SITE SURVEY  
ROCKY TOP CAMPGROUND – EL PASO COUNTY, COLORADO

SITE SURVEY – PORTION NW 1/4 SEC. 9, T13S, R68W OF THE 6th P.M., EL PASO COUNTY, COLORADO

# Site Plan Drawing\_v2-redline.pdf Markup Summary

PLOT PLAN

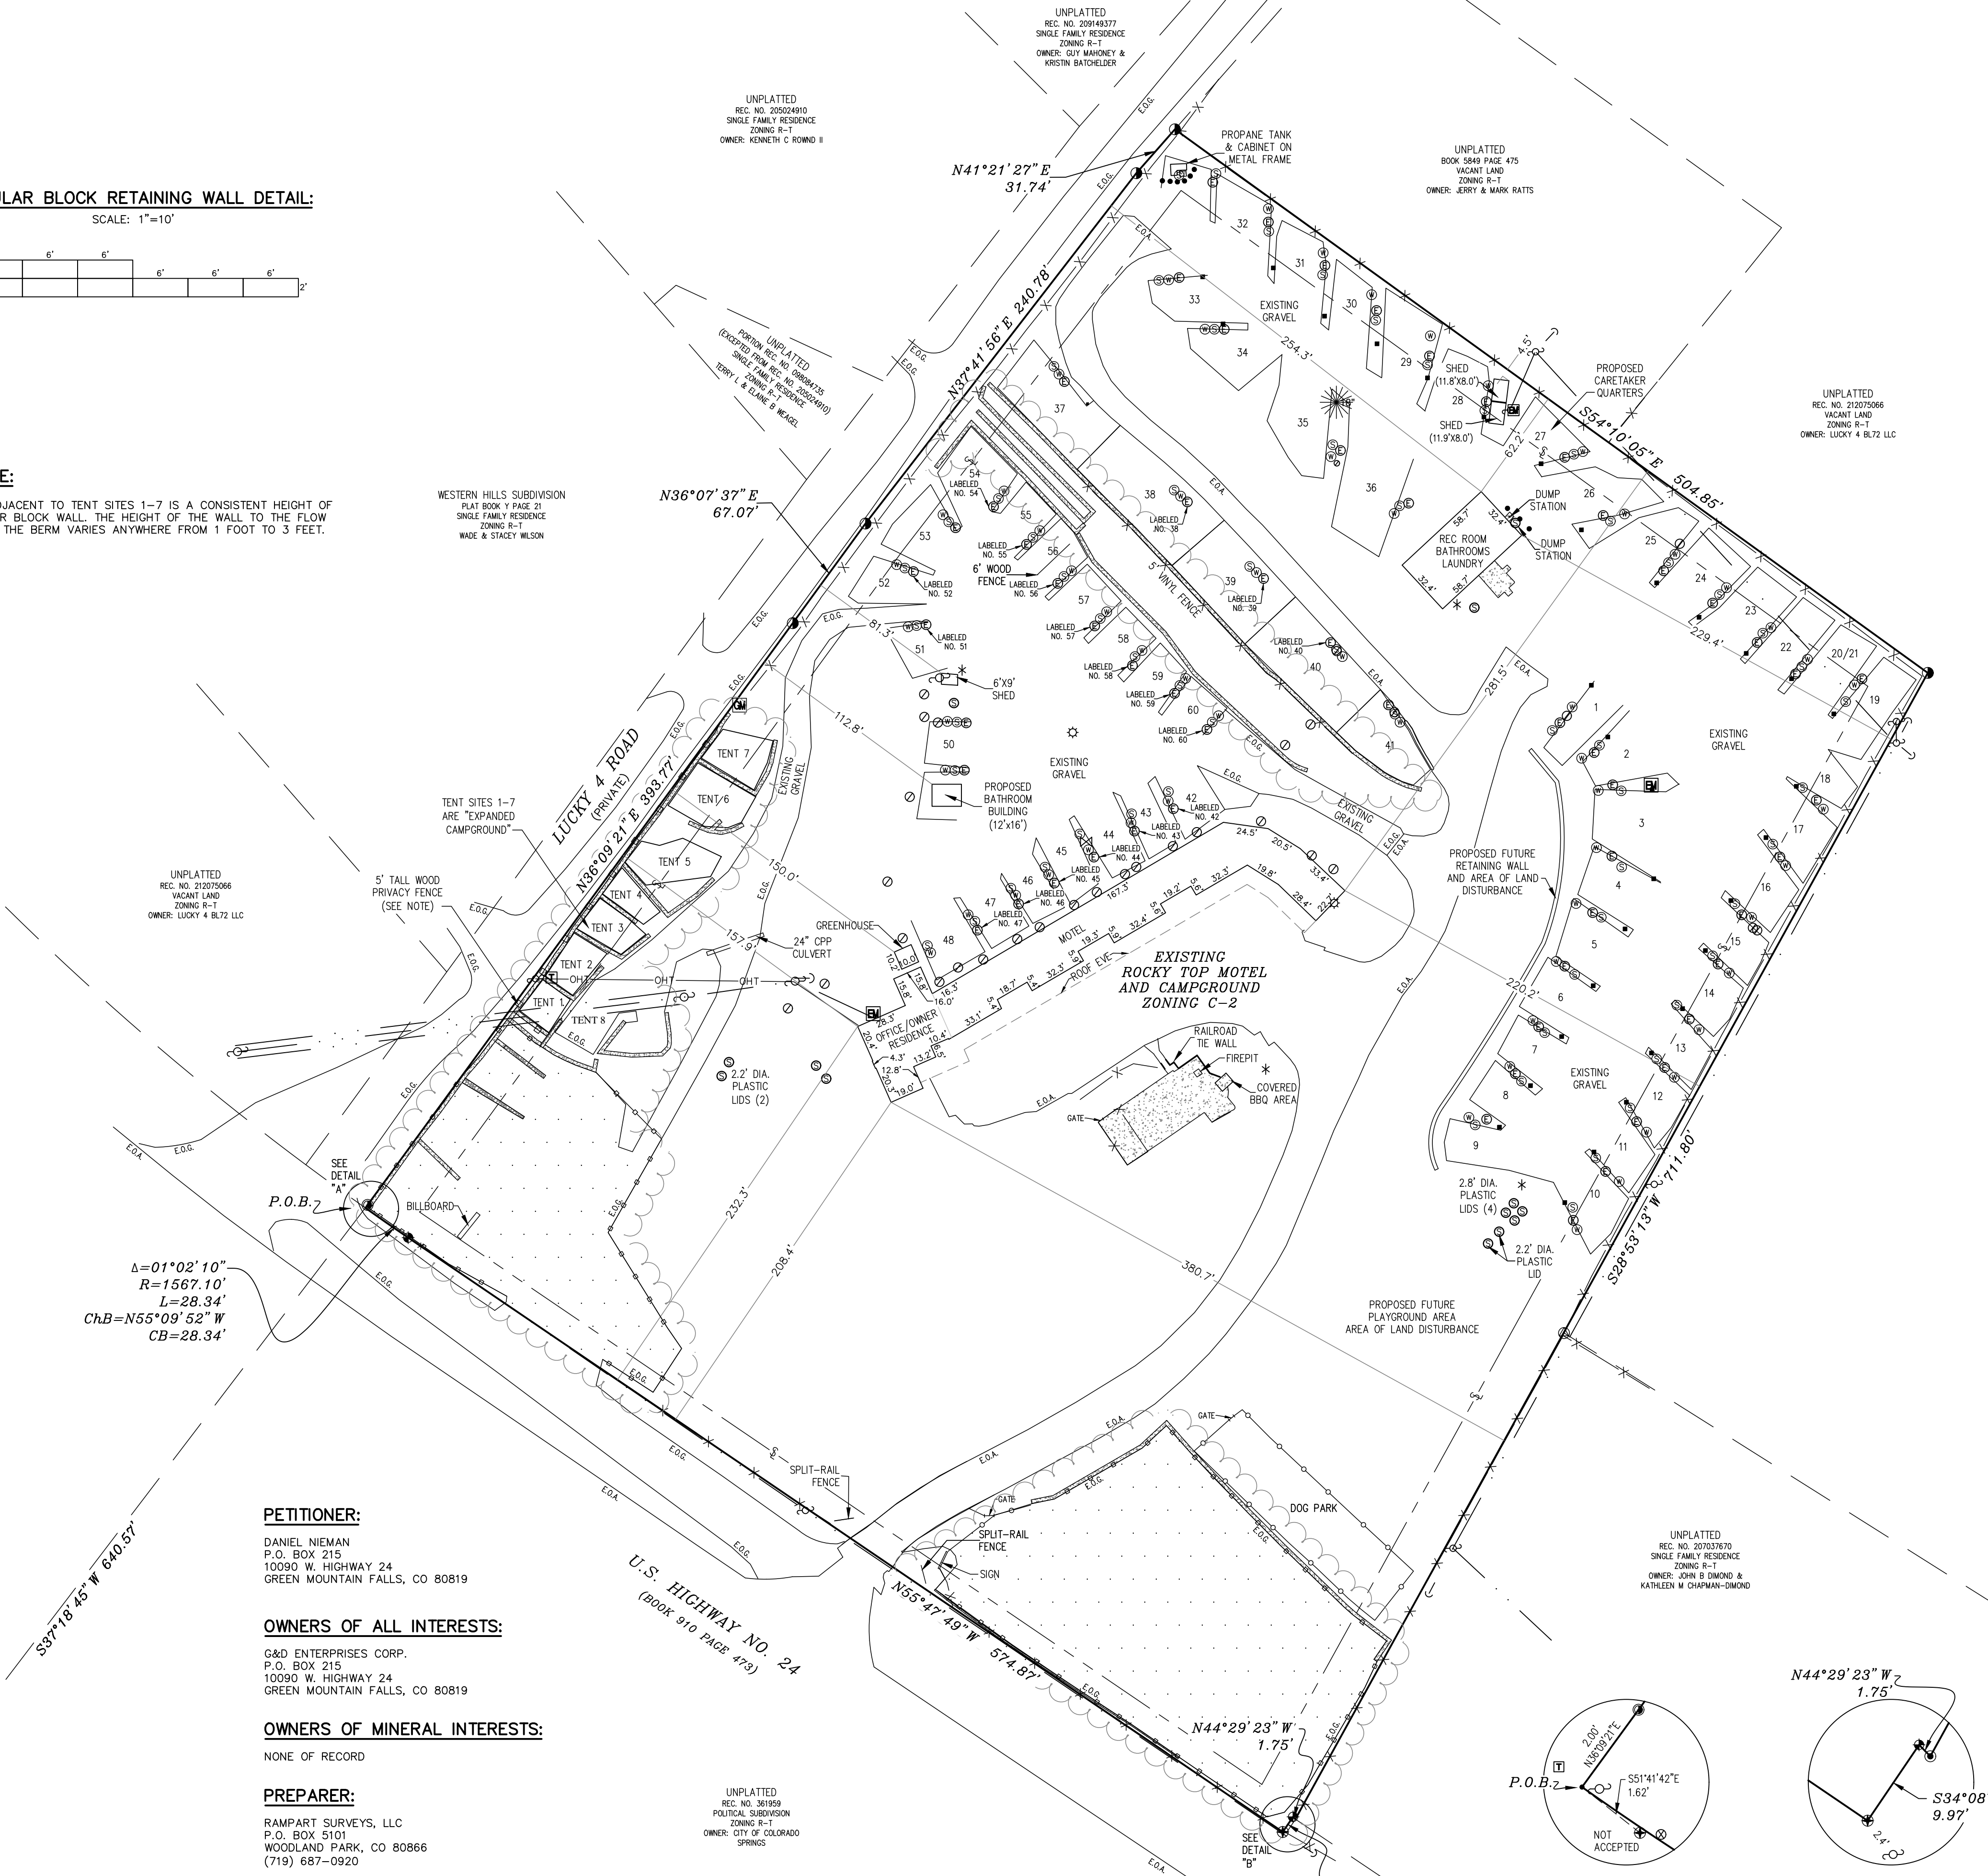
Identify existing areas and proposed areas of land disturbance.

Which areas of gravel are existing and which are proposed/have already been installed recently?

Where is the caretakers quarters?

Show setbacks to structures from property boundaries.

Show height of fence and berm/wall.

Mark these as expanded campground.

Show the proposed 12' x 16' buildings.

Based on a recent site visit, it appears that an additional section of retaining wall has been constructed along here. Accurately show the retaining wall.

Is the RV Storage gone? Label it if it is still there and being proposed.

How may RV's can be stored?

Identify the area of land disturbance
